Addendum No. 2

RE: Contract # C204746

Forsyth County (U-2579AA)

FUTURE I-74 (WINSTON-SALEM NORTHERN BELTWAY)

-Y2FLYAB-

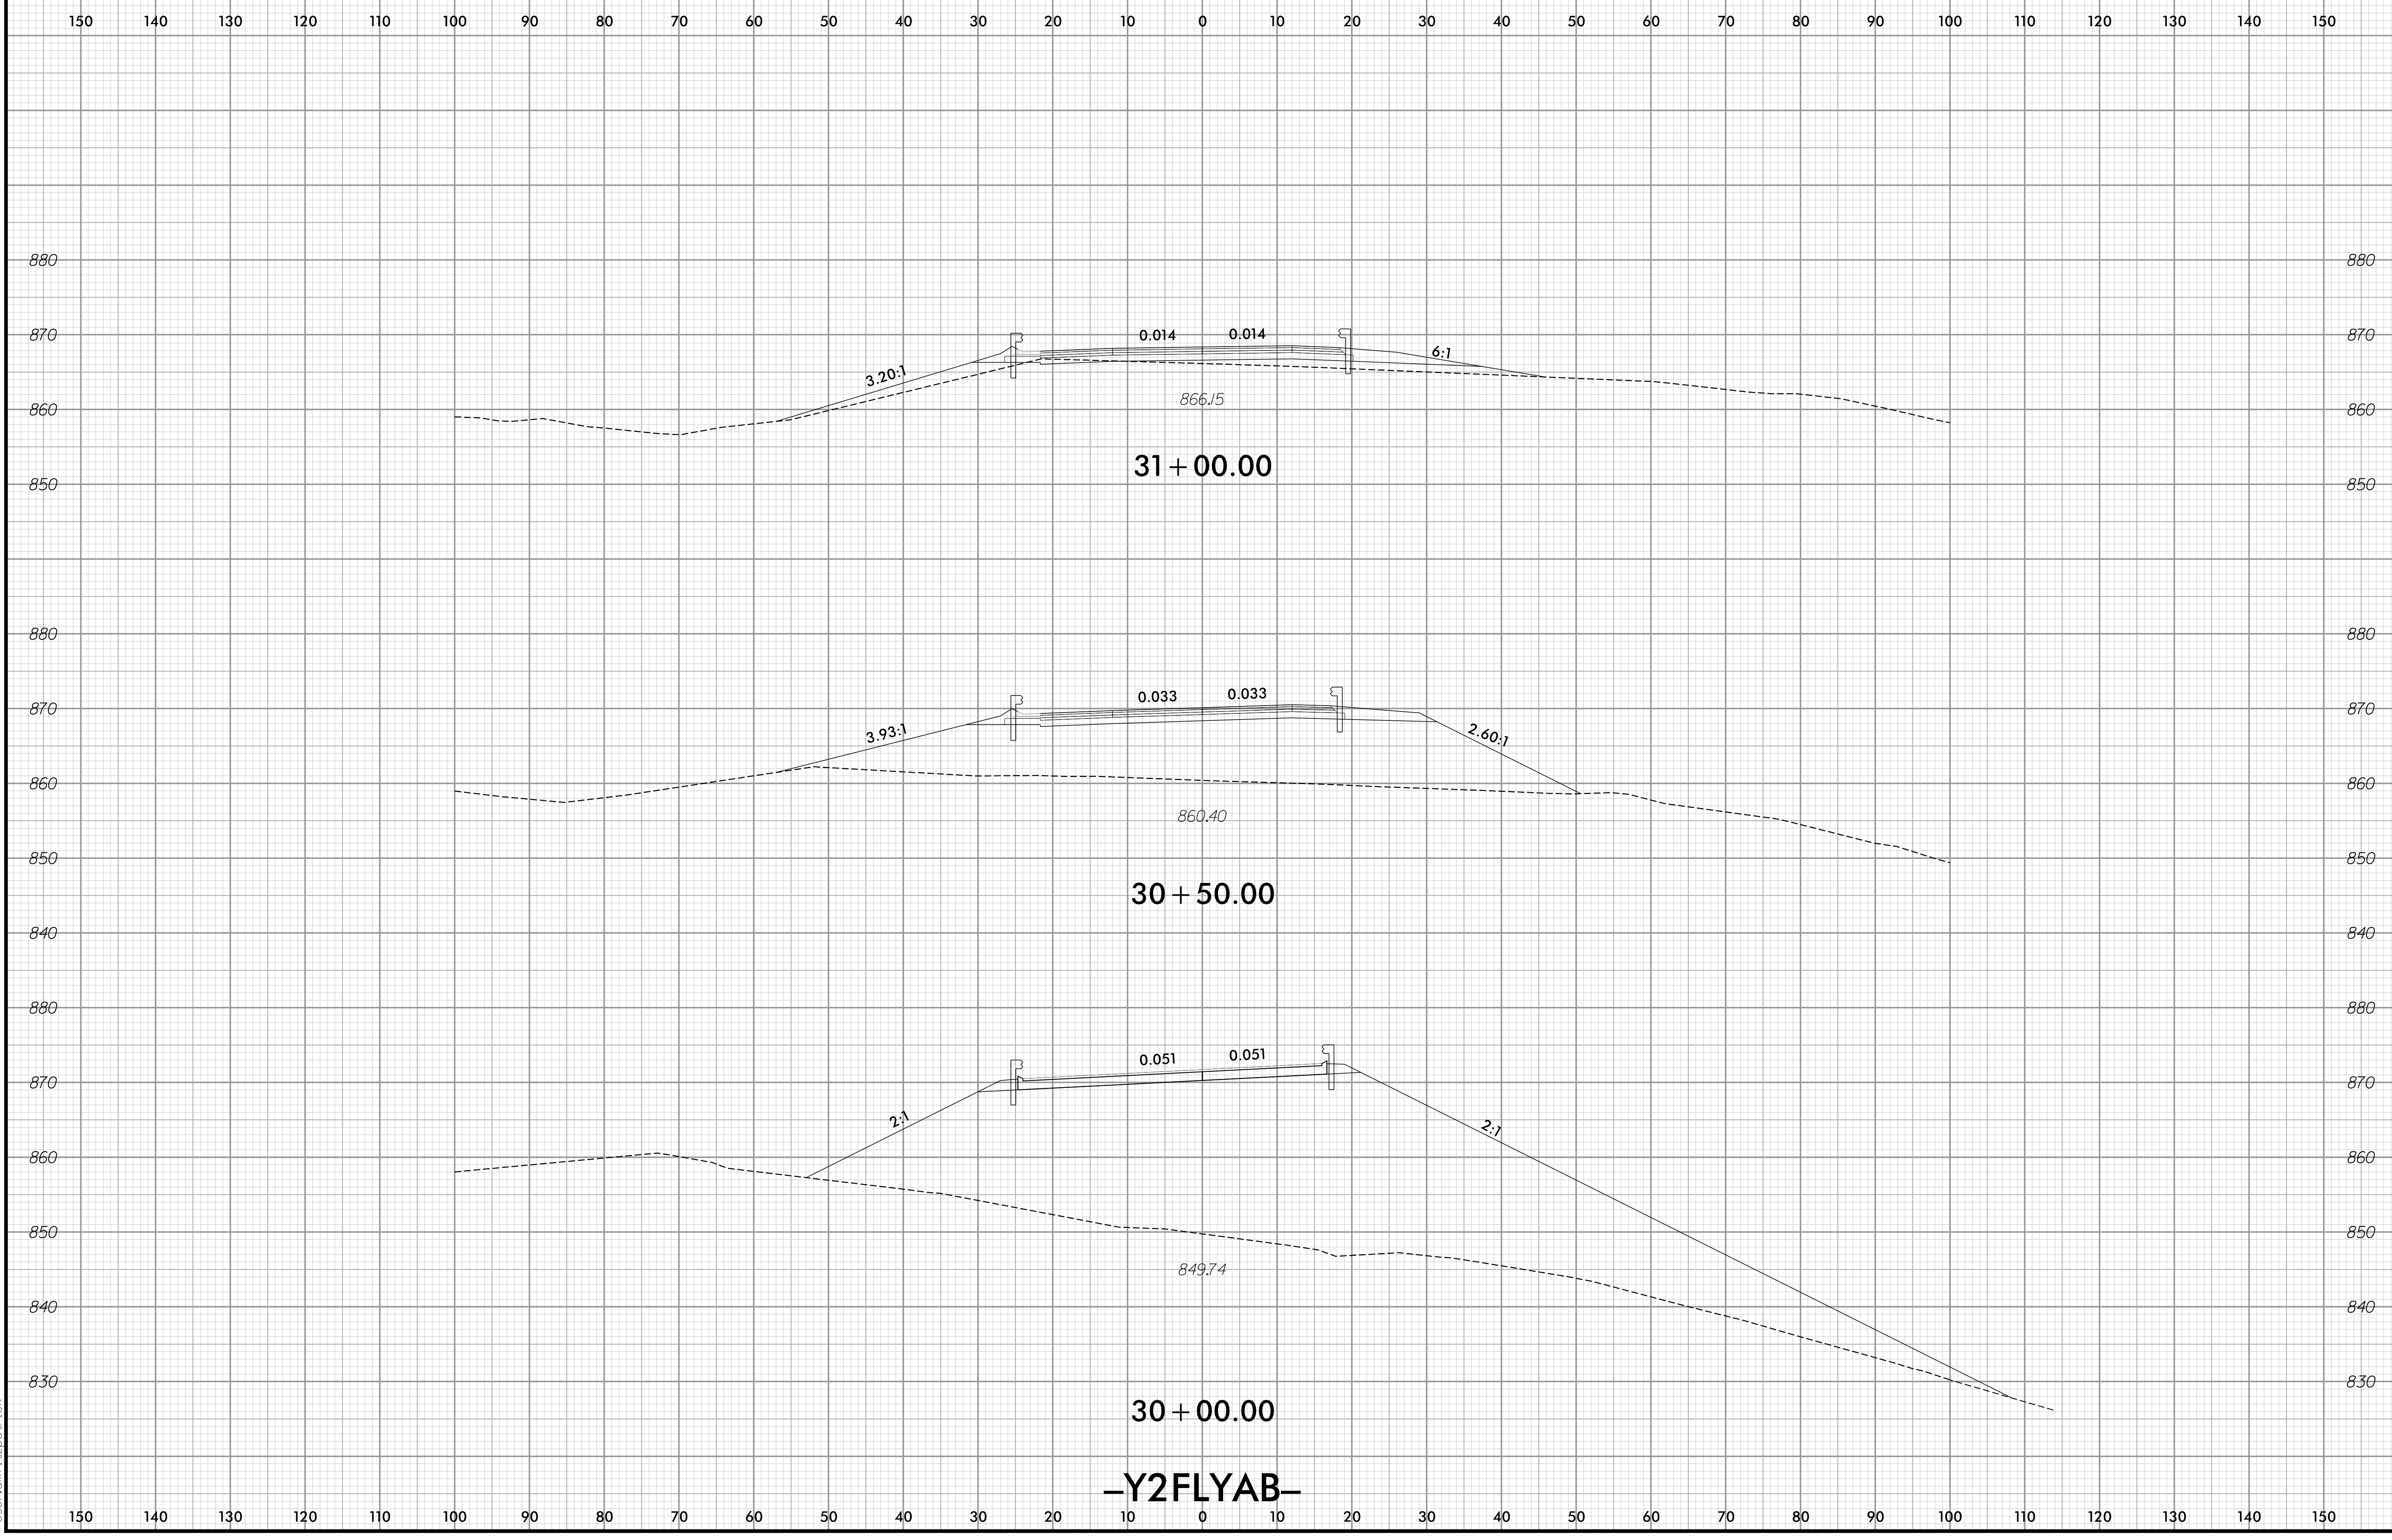
Sheet No.	Revision
X-75	MSE wall removed from Cross Sections on this sheet.
X-238	-Y2FLYAB- Sta. 30+00 fill slope on the right side revised to a 2:1.
